From: Darren Cowling [REDACTED]
Sent: 03 August 2022 14:16
To: Emily Jackson
Subject: FW: Cottam Solar Project Consultation

From: Darren Cowling
Sent: 01 August 2022 14:30
To: CottamSolar@dalcourmaclaren.com
Subject: Cottam Solar Project Consultation

With regard to the ongoing consultation process regarding the above project I would advise that the extent of the overall development covers areas under the control of The Isle of Axholme and North Nottinghamshire Water Level Management Board and Trent Valley Internal Drainage Board.

Figure	Cable Route Crossings		
Job	Cottam		
Client	Island Green Power		
Figure No.	1	Revision	A
		Date	04/11/2022
Drawn	BB	Checked	JR
		Scale	1:70,000 @ A3
Job No.	21-1088.01		Central GR
			485466E 387794N

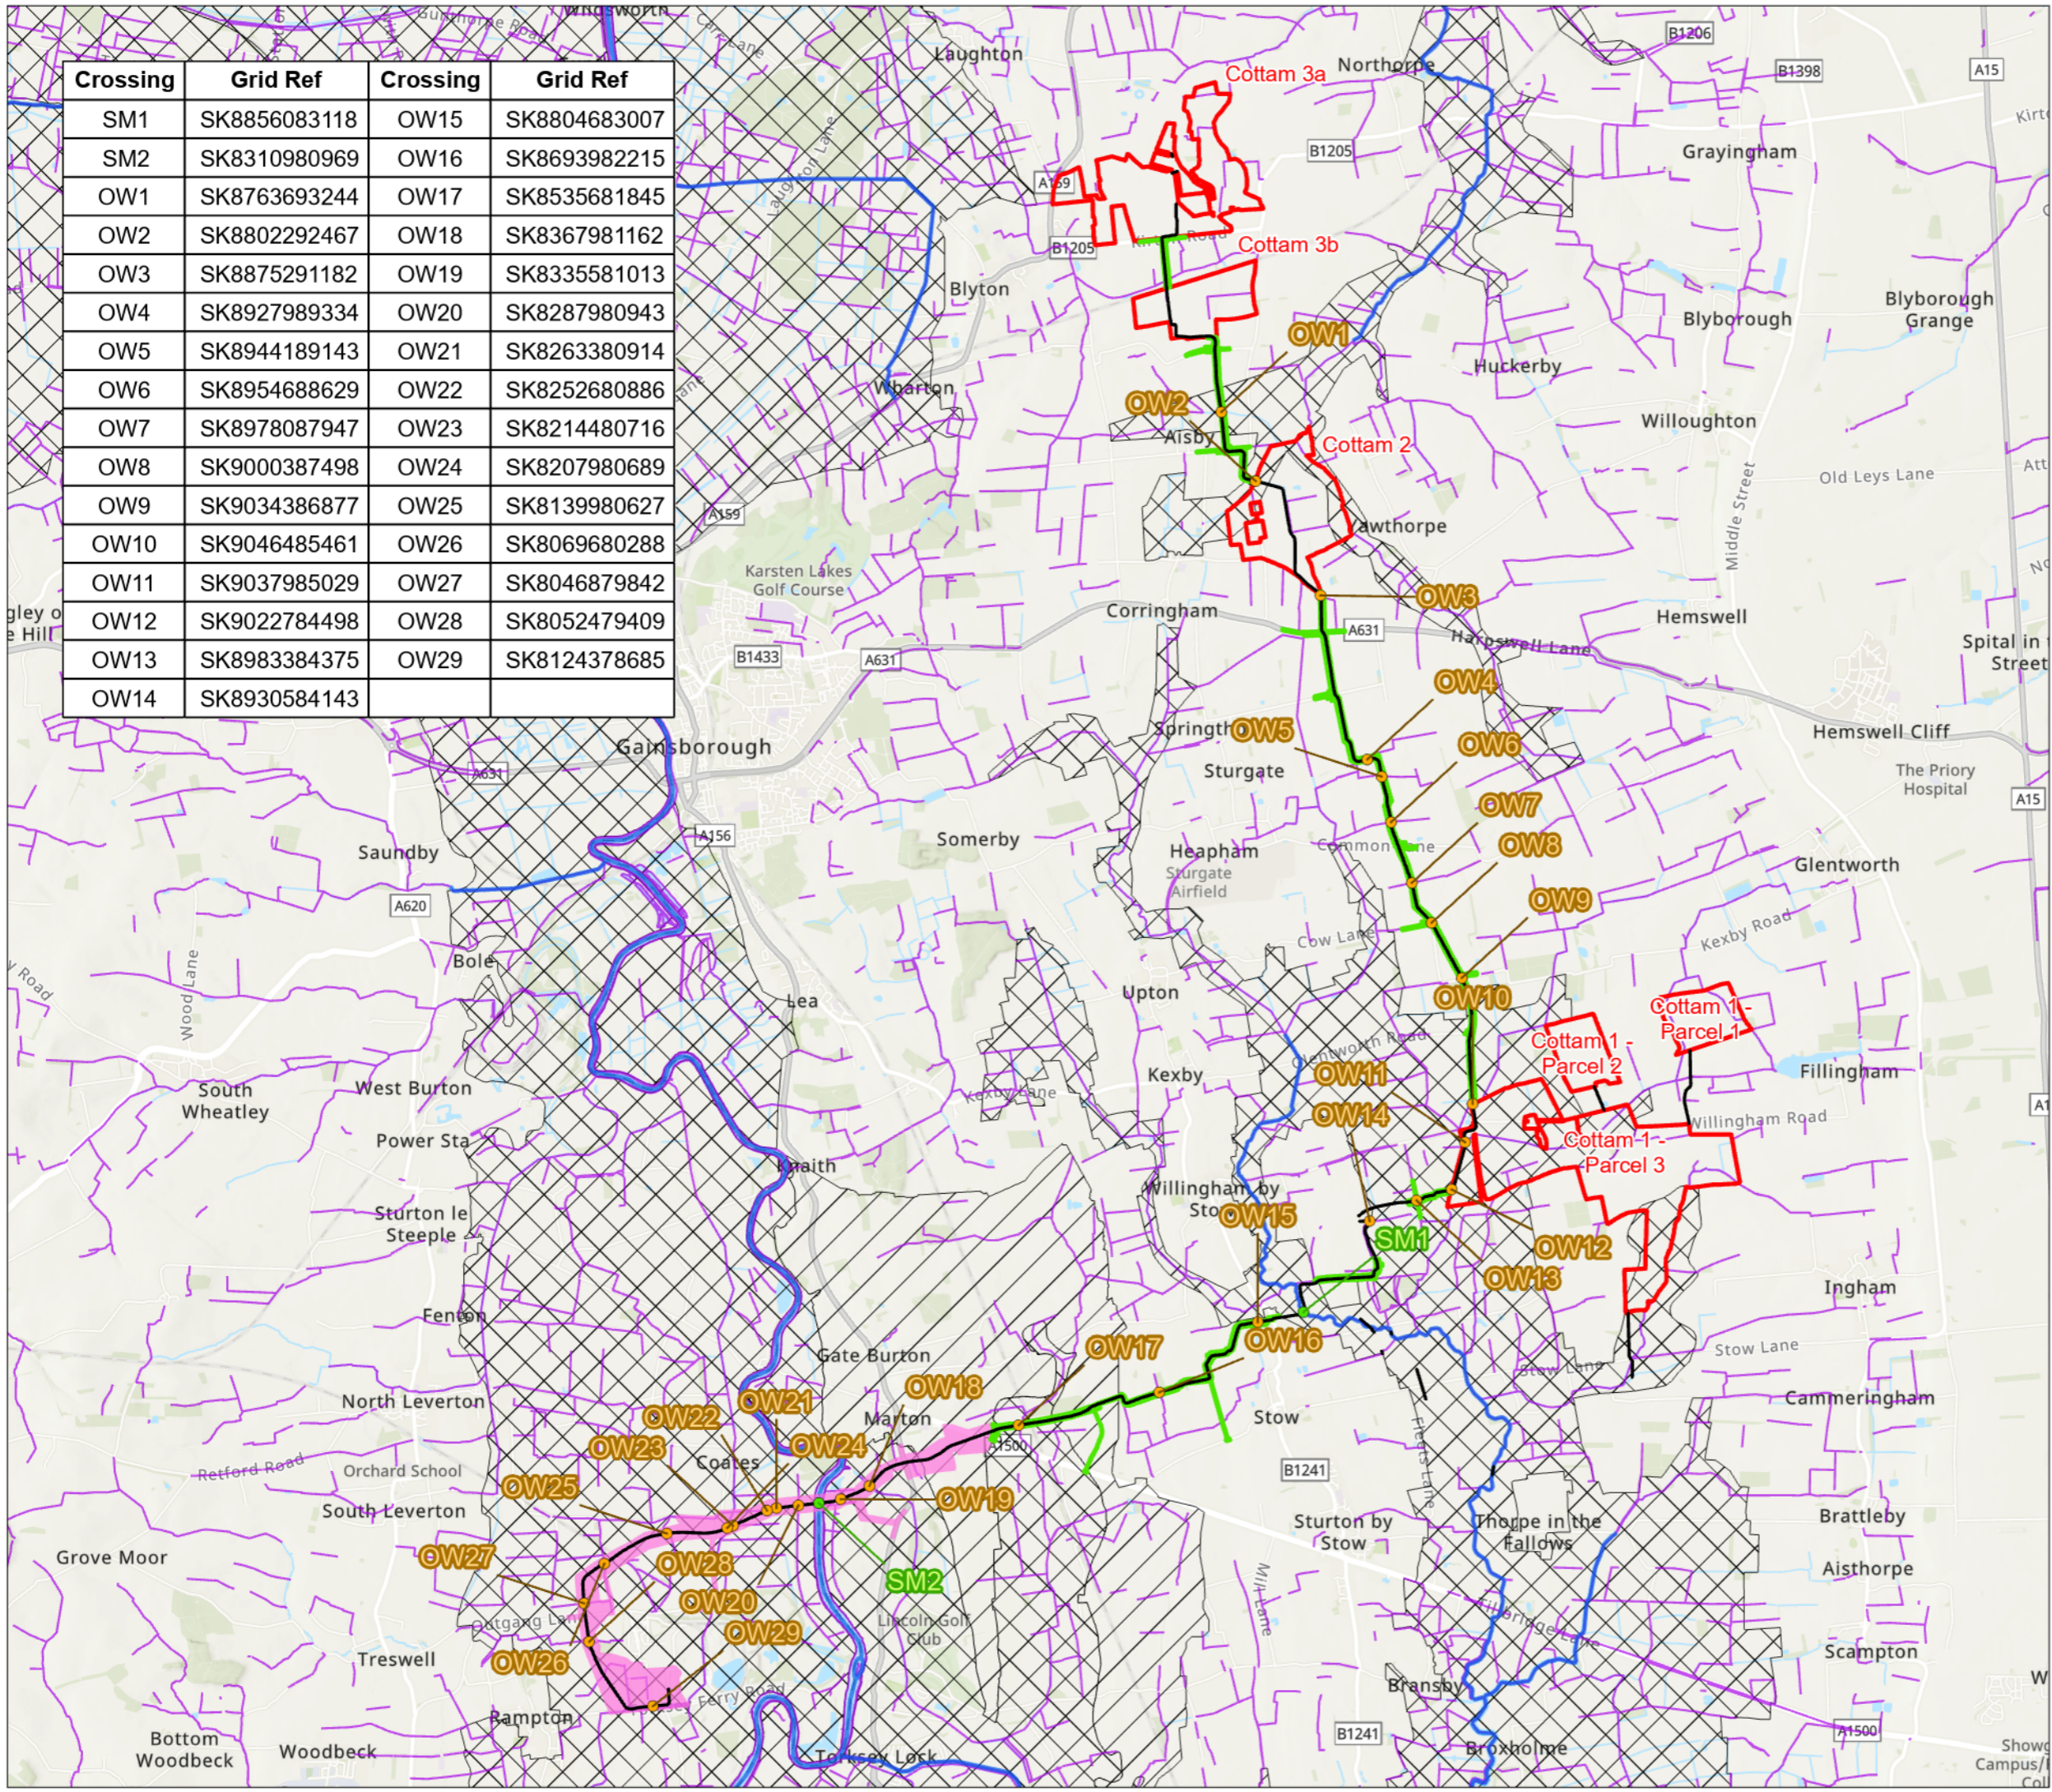
Along the cable route ALL Board watercourses are to be crossed by HDD. The minimum depth of cover from hard bed level is 1.5m. However, from experience this would generally be closer to 3m for this type of crossing. This requirement should be covered by Protective Provisions within the DCO. This matter should be discussed further and in more detail as the proposed cable route is refined.
